Memorandum

To: Kittitas County Public Works
From: Jeff Johnson, P.E.
Date: June 6, 2013
Re: Black Horse Subdivision – Flood Risk Review

Watershed Science & Engineering (WSE) was asked by the Kittitas County Department of Public Works to provide an independent general review of potential flood risks that may impact the proposed Black Horse at Whiskey Creek residential subdivision development. The subdivision is located northwest of the City of Ellensburg on an undeveloped 80 acre parcel that is bordered by three county roads and an undeveloped parcel to the west (Figure 1).

JOB NO.:	410-028-005
DWG. NAME:	PP-01
DESIGNED BY:	EGL
DRAWN BY:	JMM
CHECKED BY:	
DATE:	04-25-06
DATE OF PRINT:

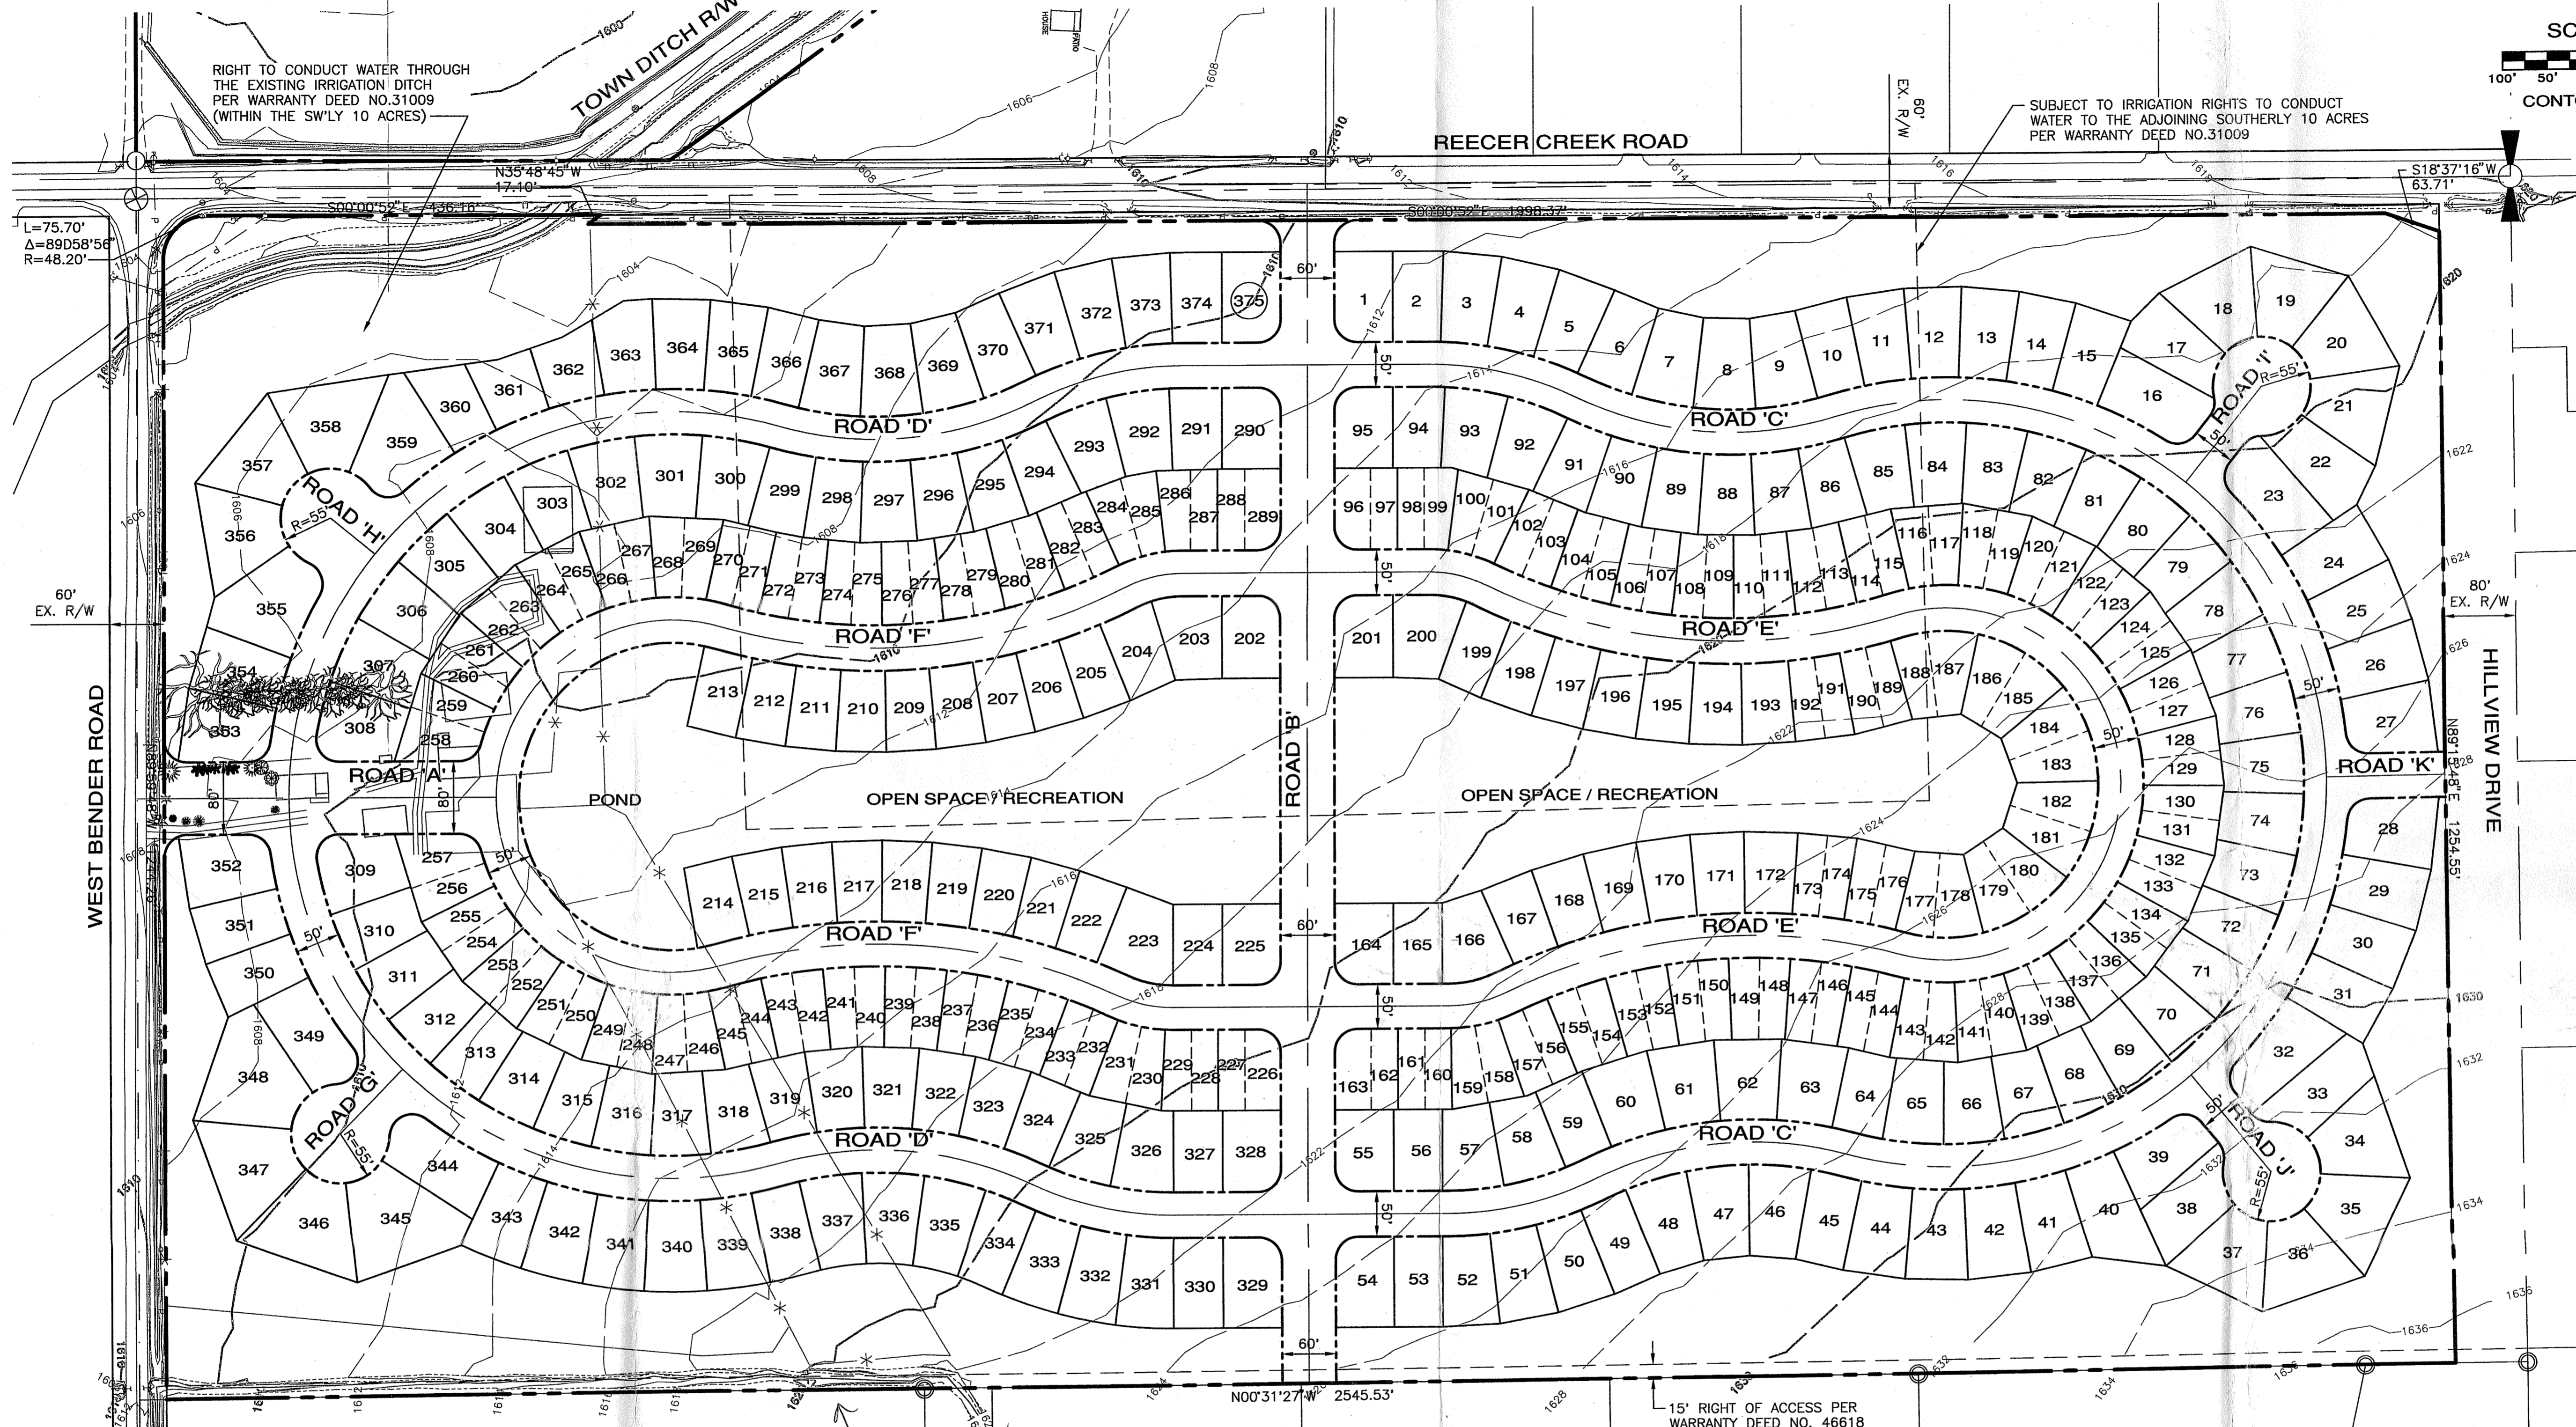
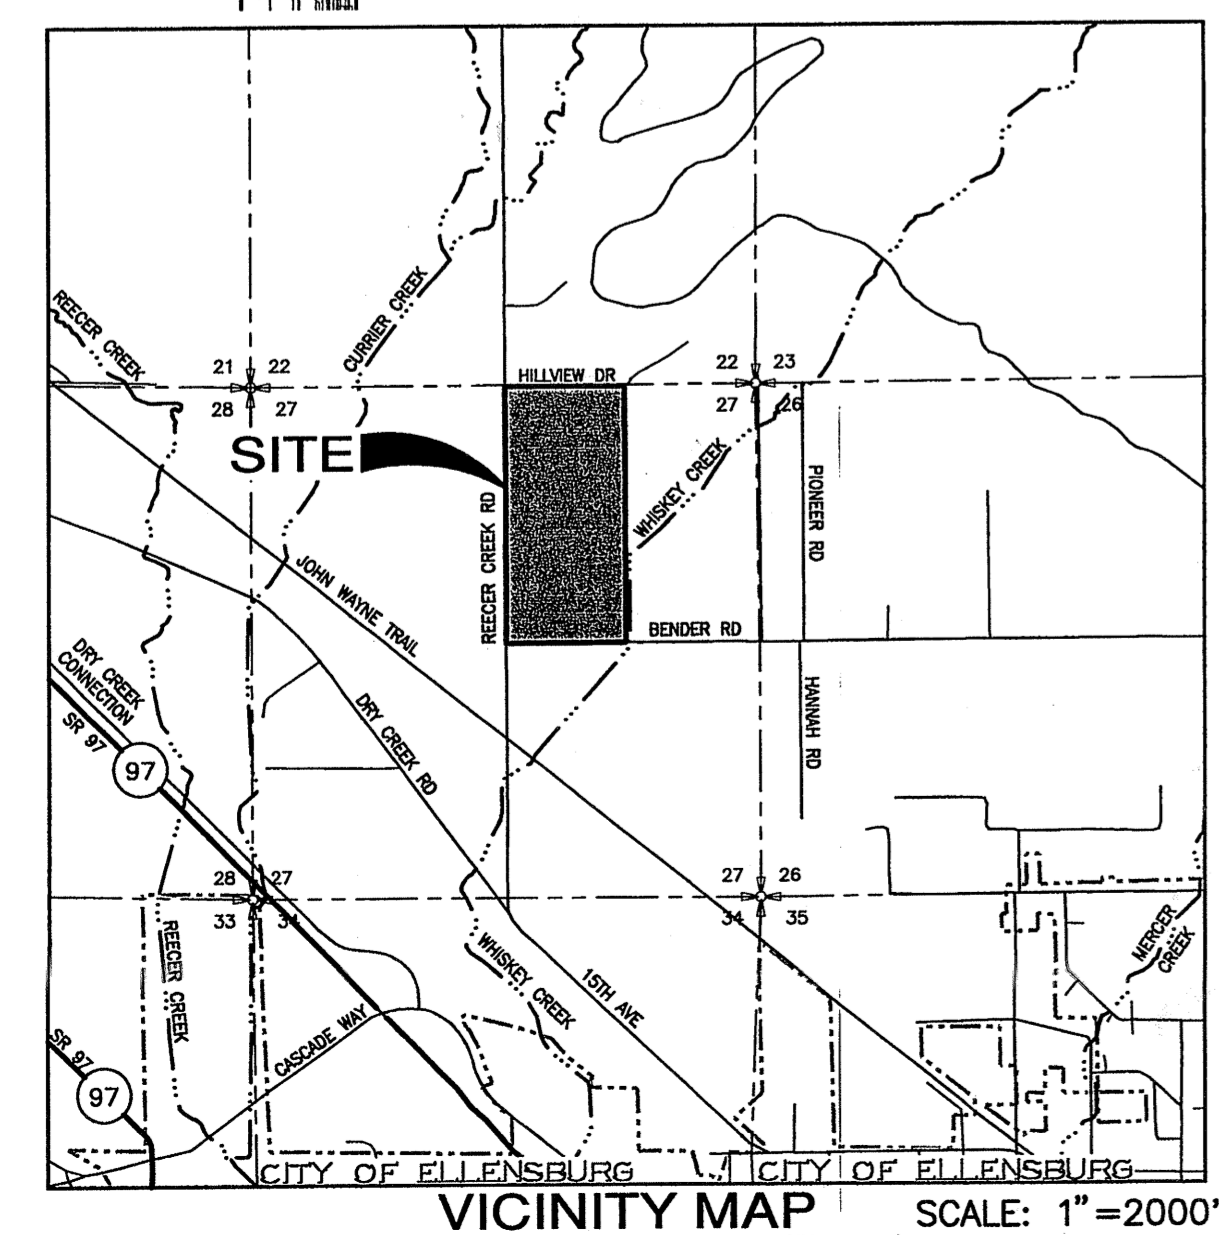
2. A relatively large earthen berm will be constructed along the southeastern edge of the development to prevent Whiskey Creek from flooding portions of the subdivision. The following question was proposed to ESM as part of the SEPA review:

A question for the County is whether the proposed berm will provide adequate and reliable protection to the sub-division. We assume that ESM is hoping that the limit of the mapped 100-year floodplain will coincide with the stream side of the berm and will not extend beyond the berm into the development. If this is the plan, then we assume someone will need to certify that the berm will provide protection from the 100-year flood. As I'm sure the County is aware, FEMA has been struggling for several years to determine how to recognize the protection provided by flood control levees and berms. In the past, FEMA has required certification by professional engineers that a levee system will remain secure and protect lands during the 100-year flood. Unfortunately, FEMA has yet to provide clear guidance to local communities as to what should or needs to be done to certify the protection provided by levees and berms. We suggest that the County contact FEMA to seek guidance on how to address this issue for the proposed berm.

3. The large wetland that exists at the southeast corner of the development was constructed to provide compensatory storage for floodwater displaced by the proposed site grading. When we visited the site on May 31, 2013, the graded area was nearly full of water. Was this water accounted for in the compensatory storage calculations or was it assumed that the graded area would be dry at the time that a 100-year flood occurs on Whiskey Creek? Further documentation or evaluation of this issue is recommended.
